19th April 2021

Application No: AW/81/21/HH
Site Address: 2 Old Farm Close Aldwick PO21 4AX
Description of works: Two storey extension.

Thank you for your internet representation made on 17th April 2021 which has been recorded as an objection with the comments as follows:

Proposed second floor plan 1:100

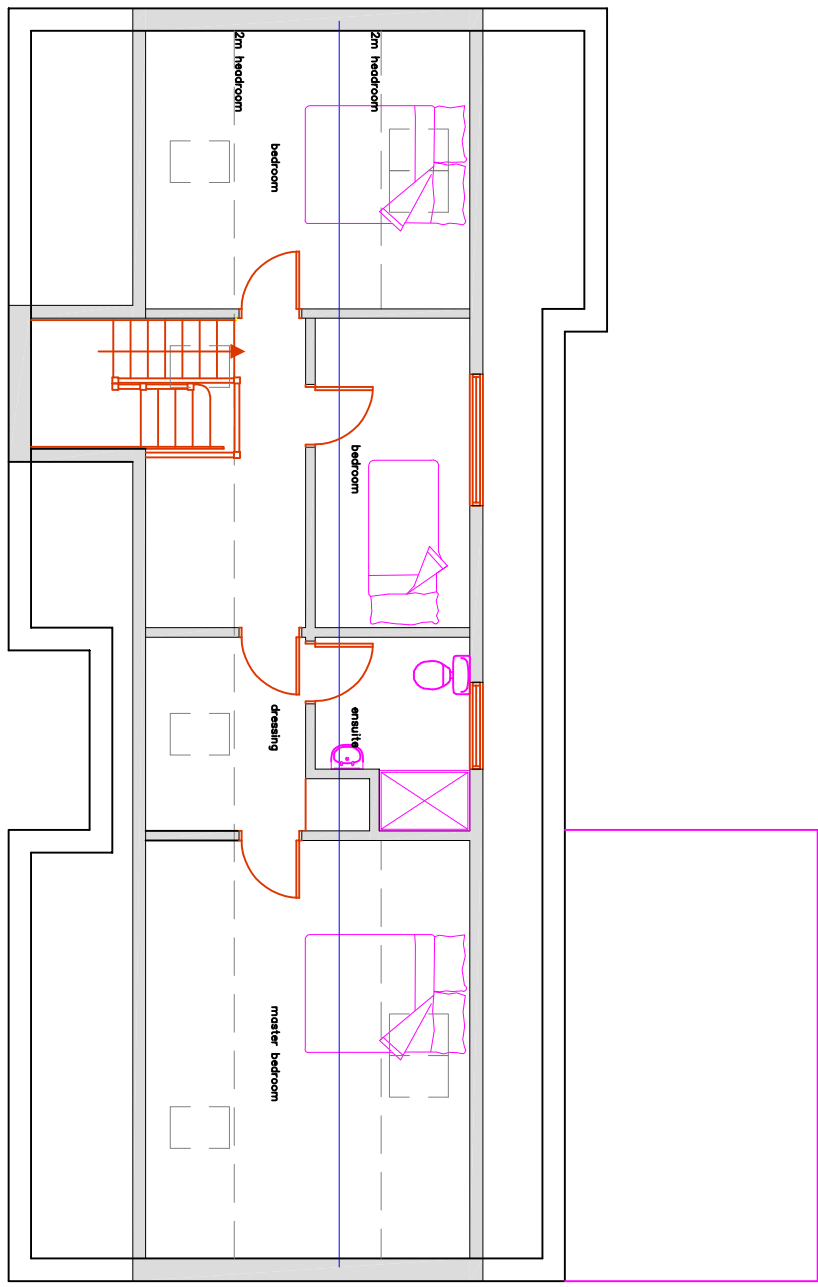
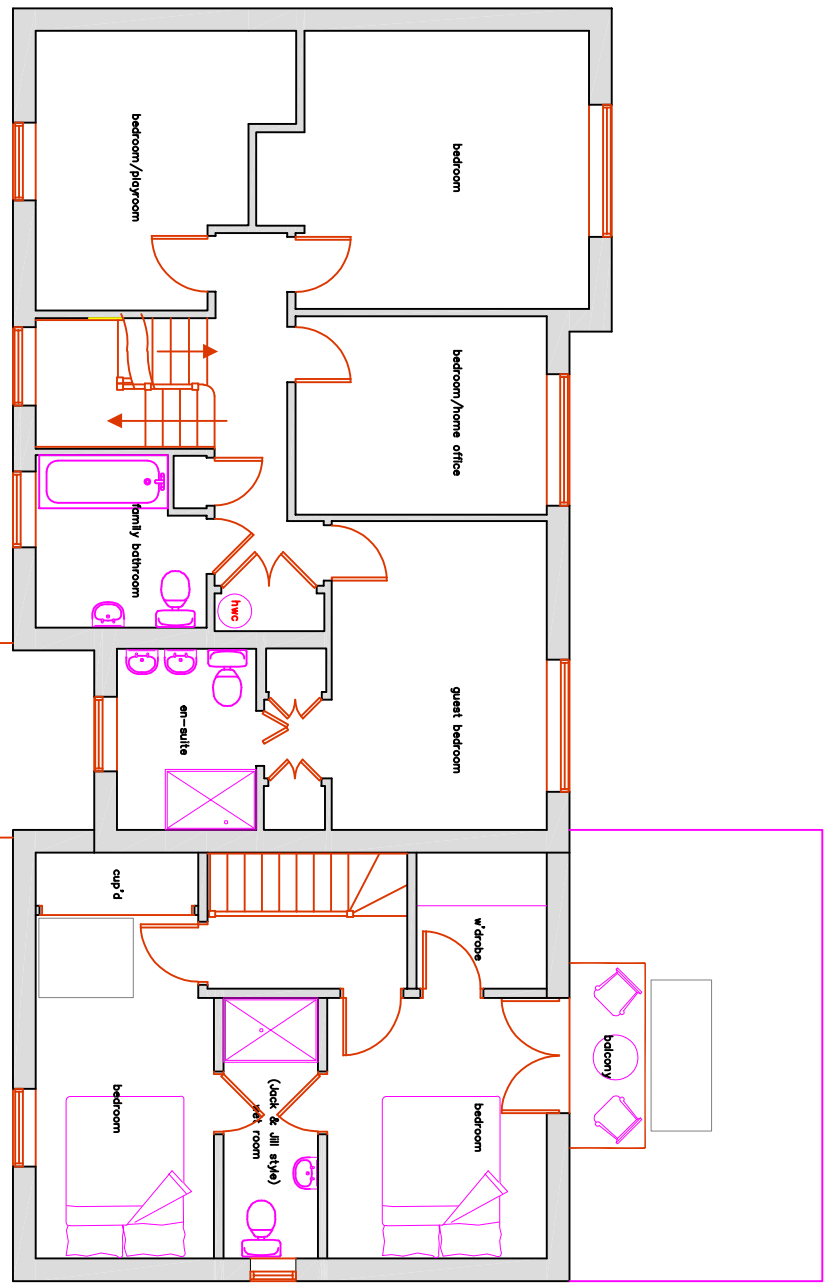
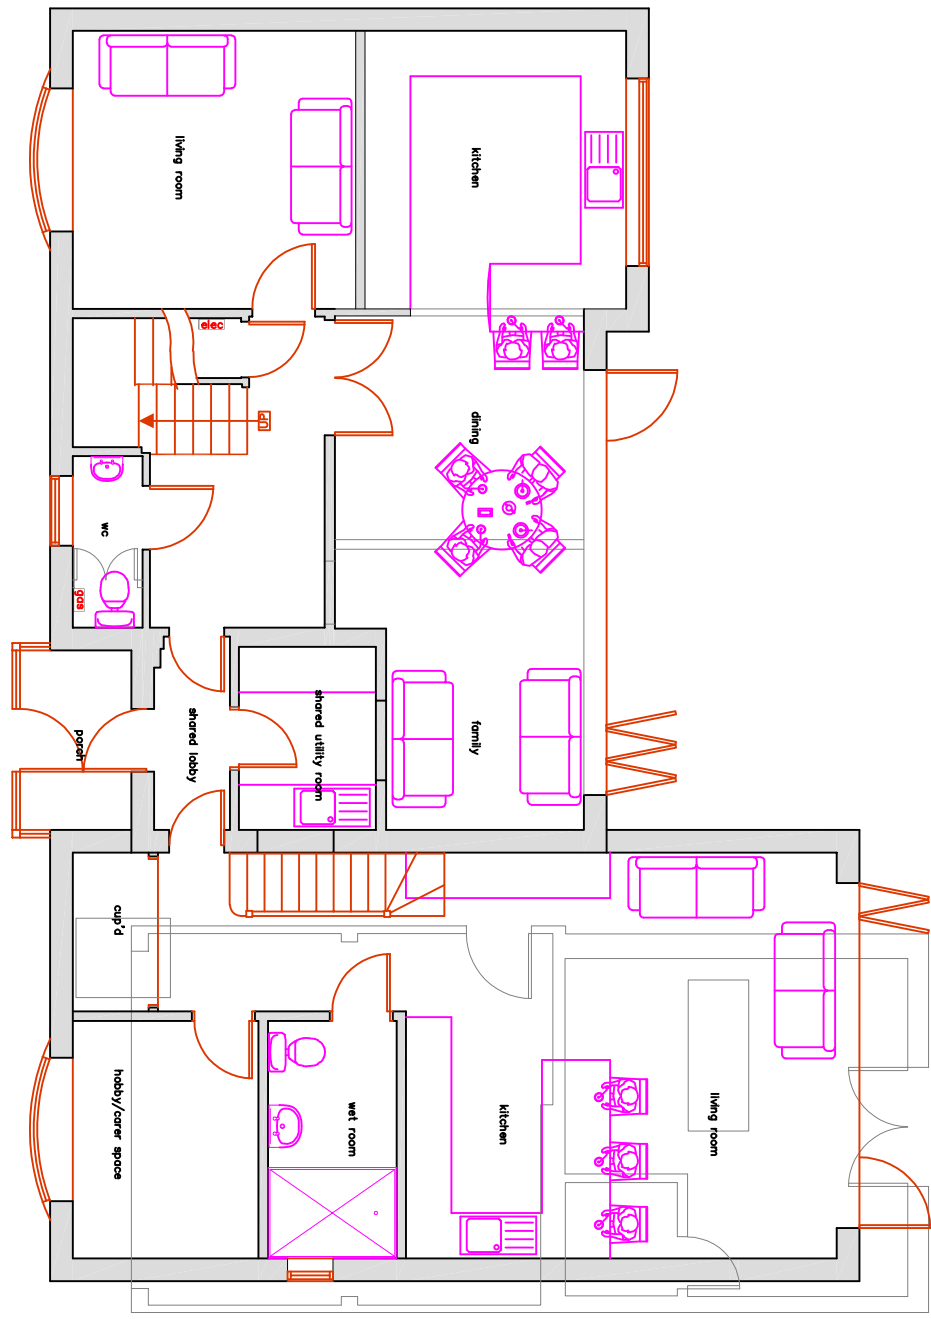
Members strongly objected to the application on the grounds that the proposed extension is built over 3 floors and would not be visually integrated the existing building in scale and having 5 extra bedrooms, would not be subservient to to the existing building. Moreover, the extension would have an adverse overlooking and overbearing effect on several neighbouring properties. Old Farm Close is a small, secluded cul-de-sac of mainly 4 bedroomed detached houses and the proposed extension would compromise the established spatial character of the existing development. Members further expressed concern about the difficulty construction traffic would have in accessing the area; the lack of parking spaces for the possible number of cars serving the building and the possibility that, at some time future, the building could become a house of multiple occupancy. Therefore Members agreed that the development is in direct conflict with Policy D DM4 (a); (b); (c) and (e) of the Arun Local Plan 2011-2031 and with the Parish Design Statement page 38: Any roof re-design should be sympathetic and in keeping with the character of existing properties. Extensions should be in keeping and well-related to existing buildings and space.
